29/09/2020

Ref No.: F2017/00406

McPhillamys Gold Mine Project (SSD 9505) Amendment Report

Figure 5.18 VP5 Mid Western Highway (East) – Existing view and Year 2
Comparison between EIS and amended project

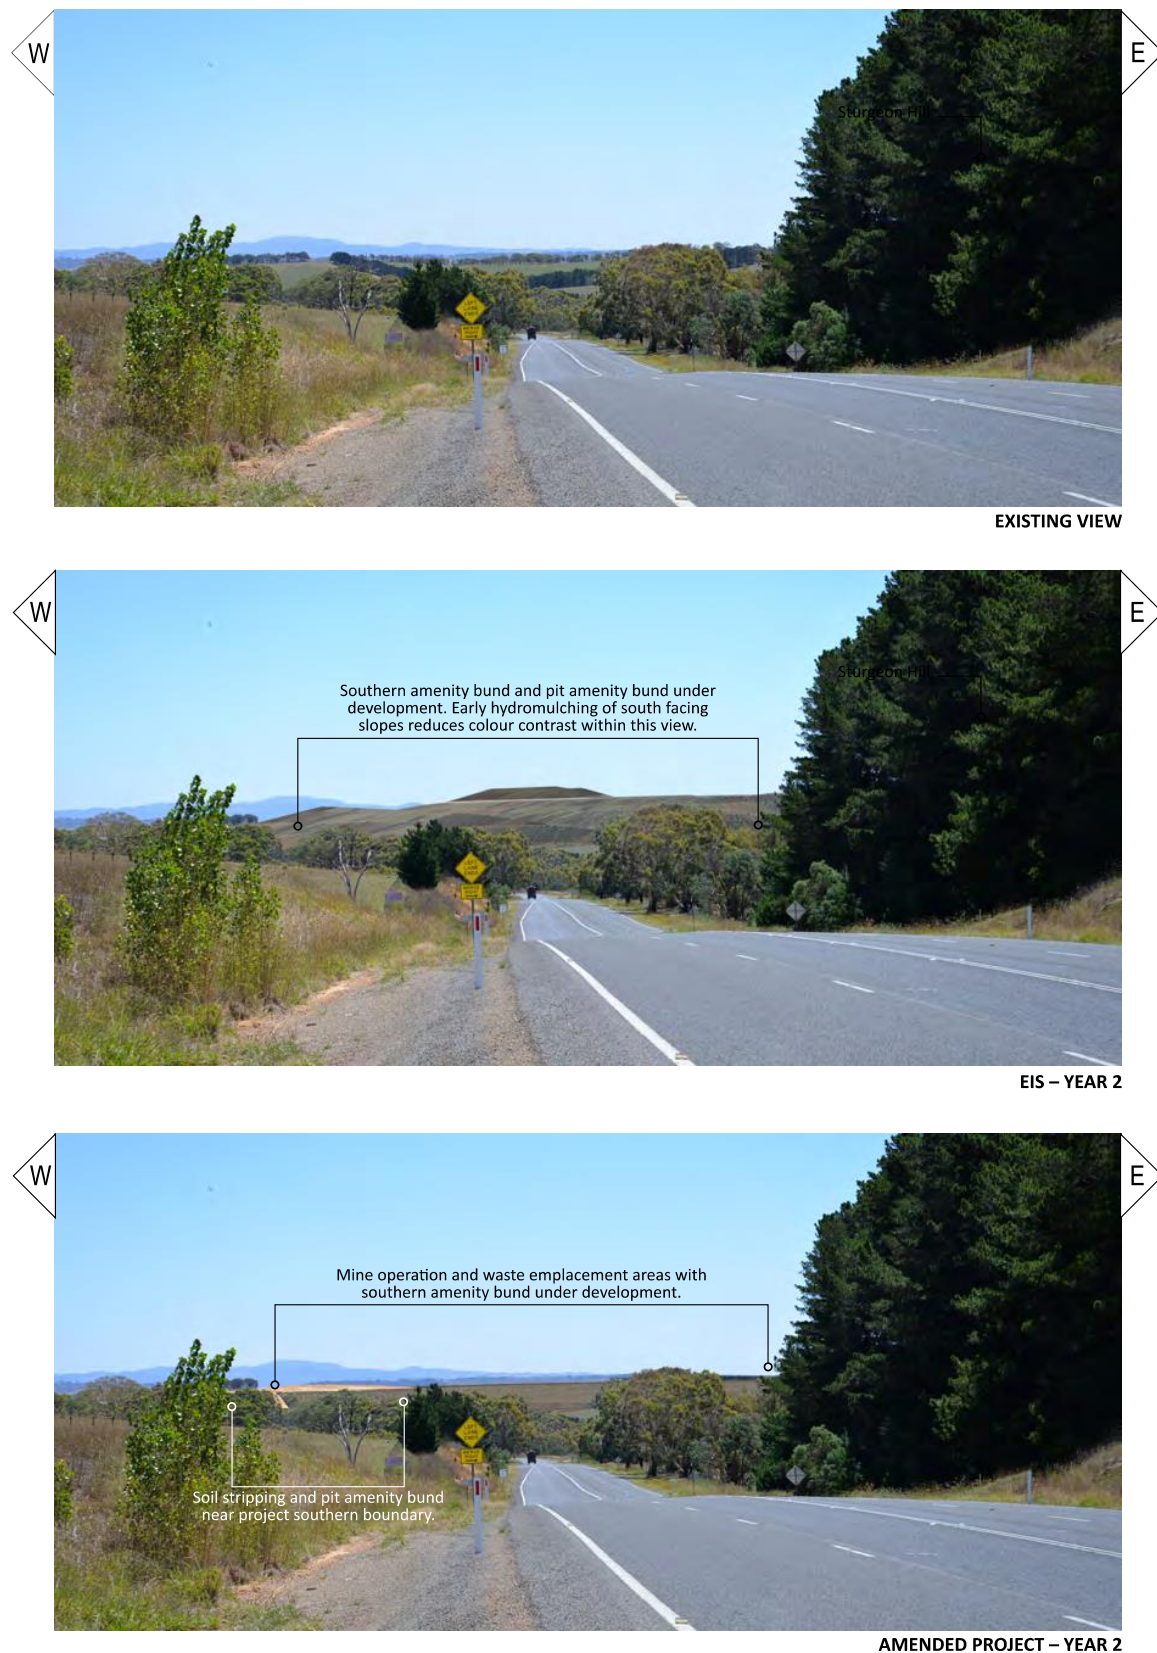
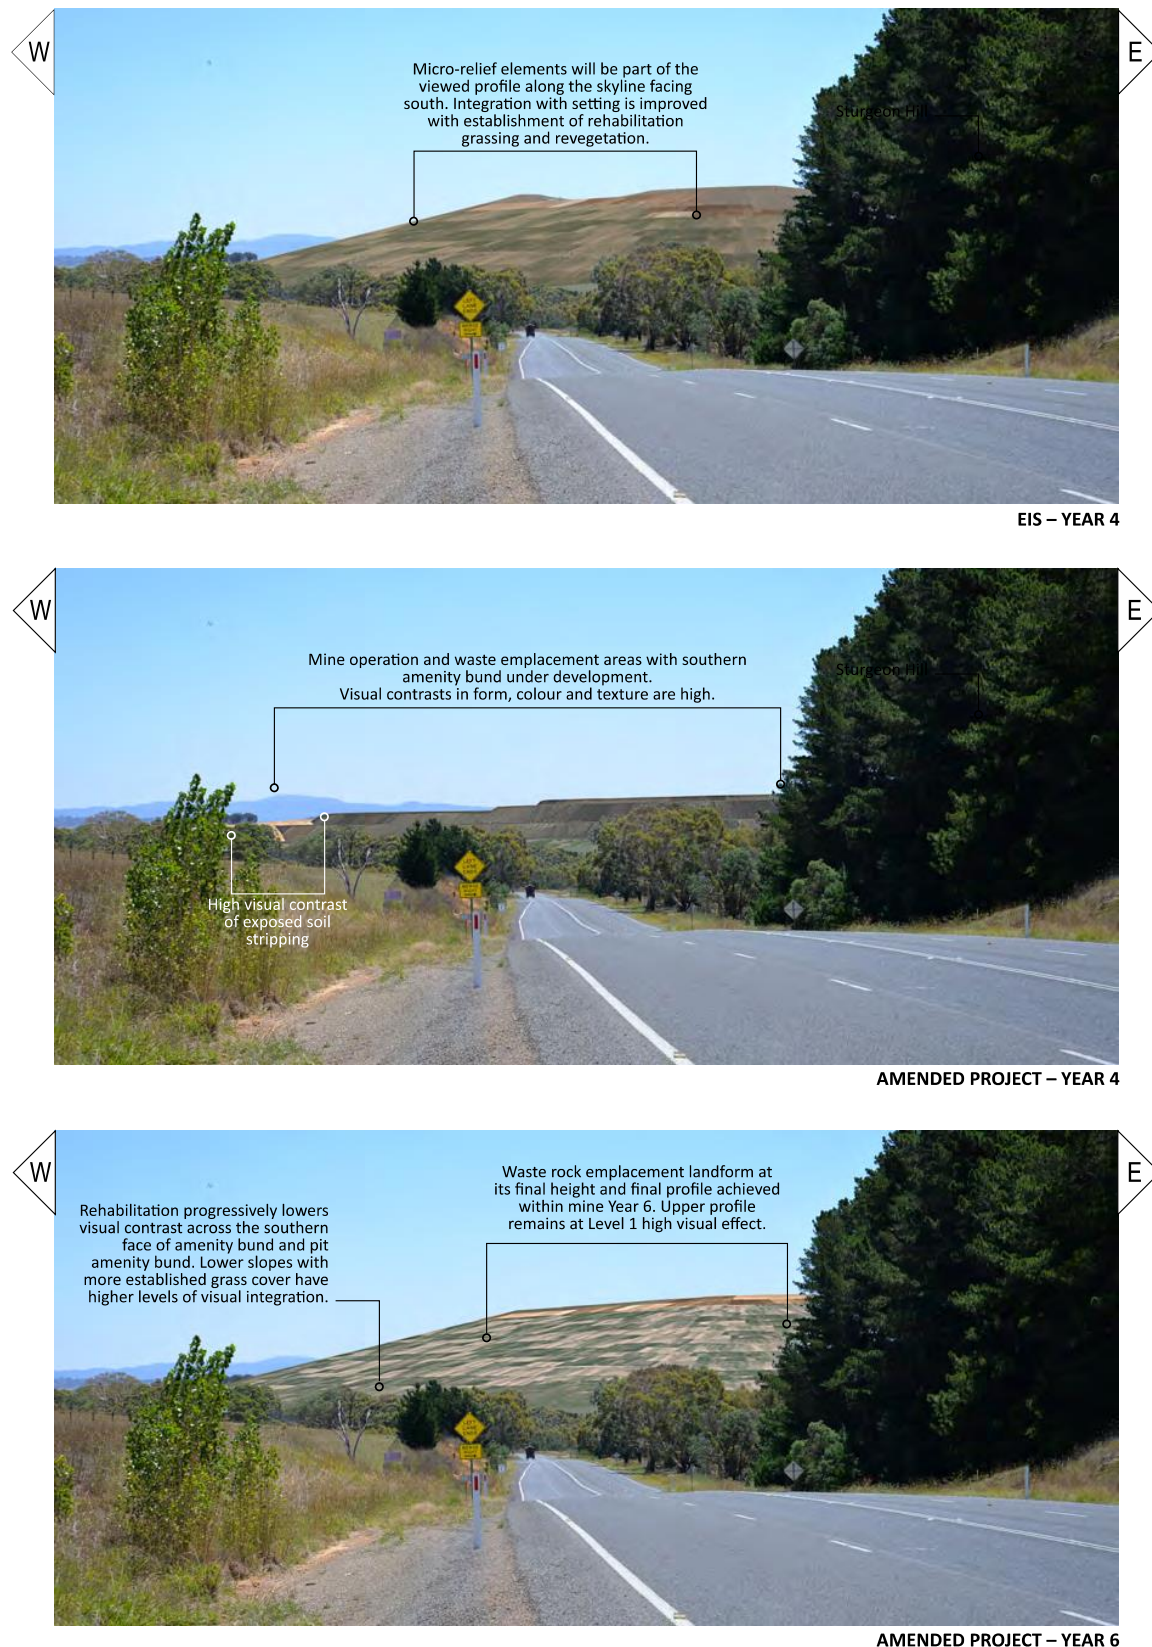
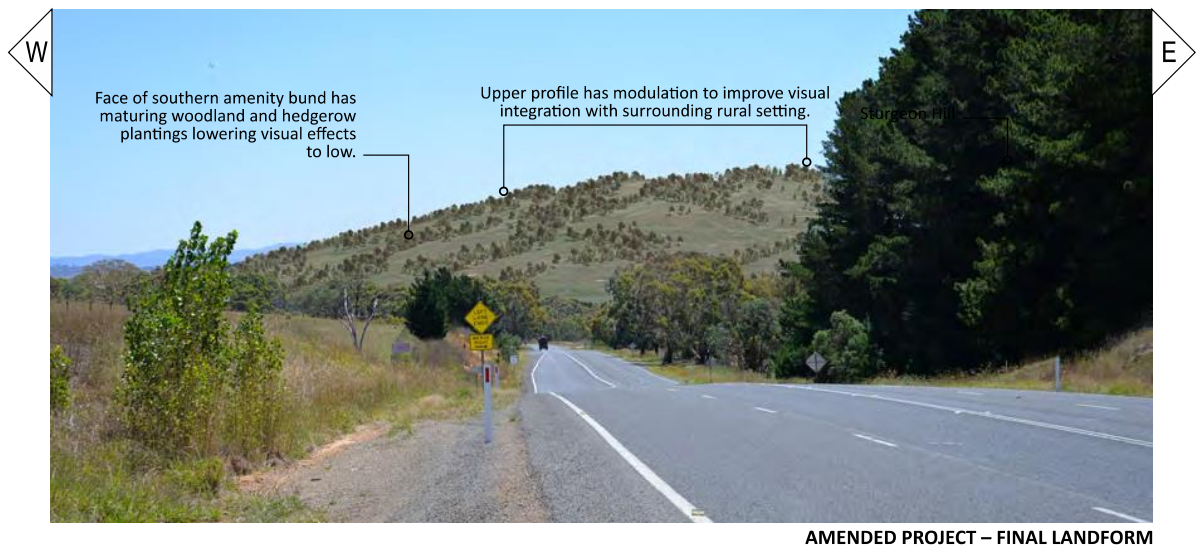
- Section 6.13.1 iv e - VP5 1st paragraph "Thick plantation pine forests to the north of the Mid Western Highway also limit view angles in this location". FCNSW would like to emphasise that plantation pine forests, whether private or State forest, are a commercial venture and are harvested from time to time. To rely on private plantation forestry or State forest plantation trees as a screen/buffer is not appropriate.
